December 29, 2020

Re: 1813 and 2000 model garage portal frame hold down repair

Sincerely,
KSE Engineering, P.C.

MONOLITHIC SLAB FOUNDATION PLAN
ELEVATION 'A'

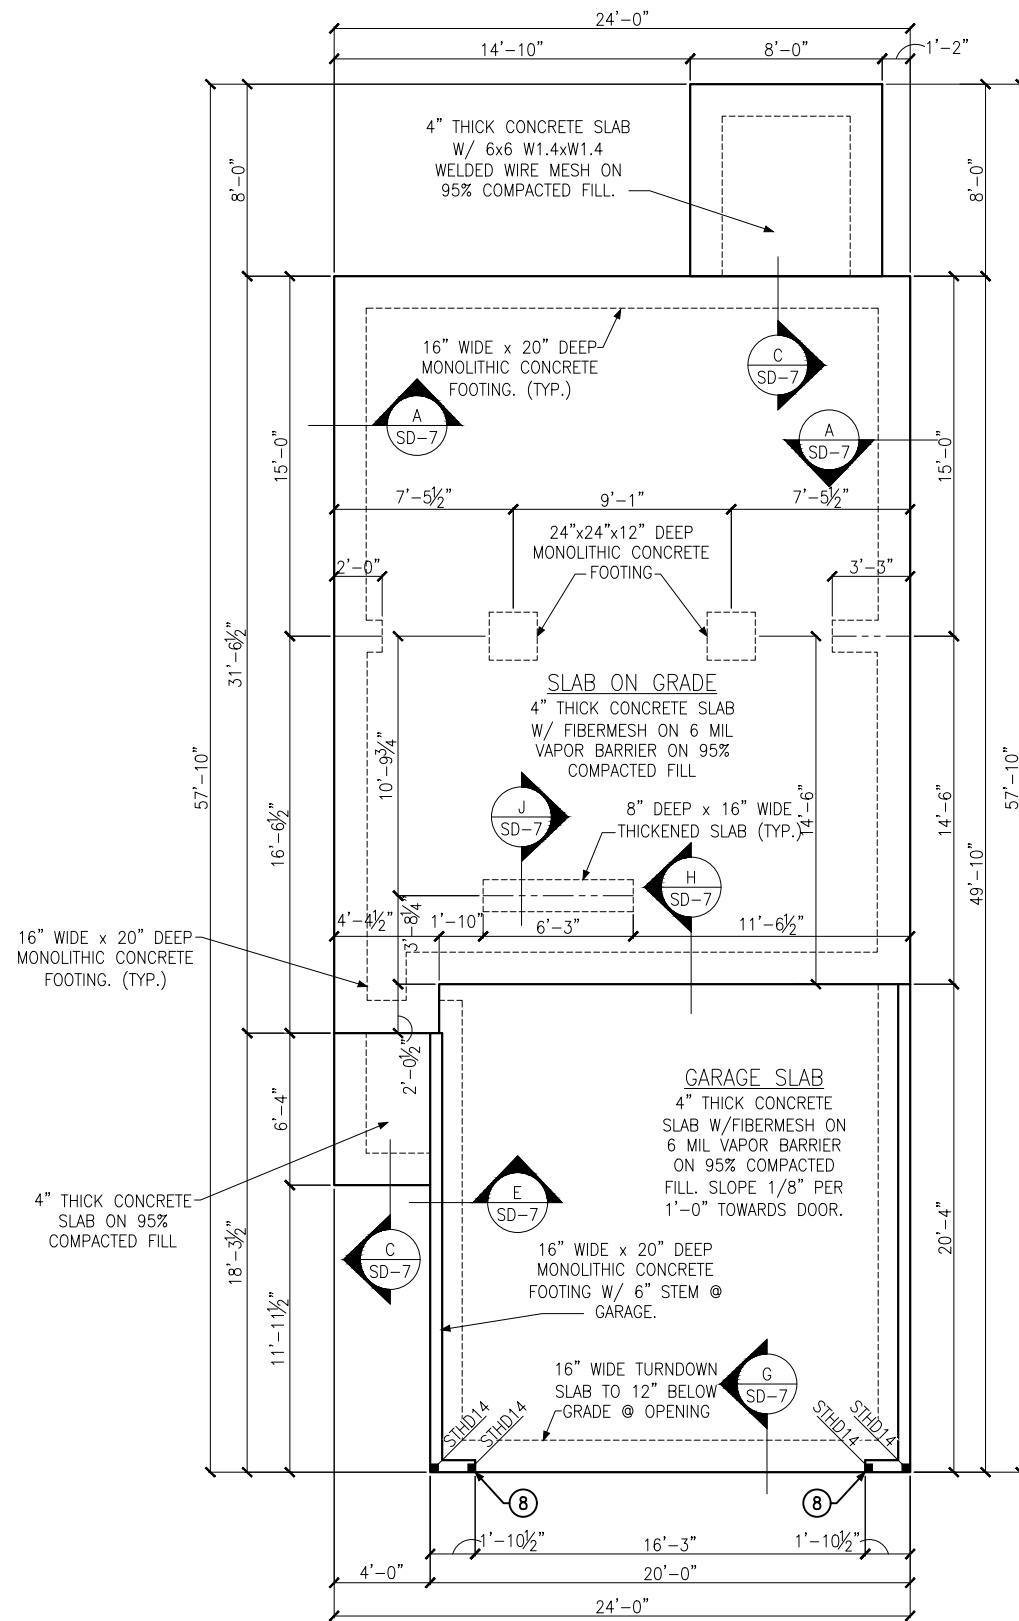
Our structural framing plans specify a portal frame with hold downs at the garage door per detail C/SD-4. The structural plans and detail call for Simpson STHD14 cast-in-place hold down straps at each end of the bracing panels. The STHD14 hold downs were not installed when the foundation was poured.

The missing STHD14 hold downs may be repaired by installing new Simpson LTT20B hold downs at all 4 locations where the STHD14 hold downs are specified on the structural plans. Anchor new hold downs to the existing monolithic slab foundation with new 1/2" diameter anchor rods drilled and epoxied into the foundation with Simpson SET-XP adhesive or equivalent with a minimum 12" embedment. If clearance for the new hold down installation interferes with existing sill plate anchor bolts, the existing anchor bolts must be cut off and reinstalled using new 1/2" diameter anchor rods drilled and epoxied into the foundation with Simpson SET-XP adhesive or equivalent with a minimum 12" embedment.
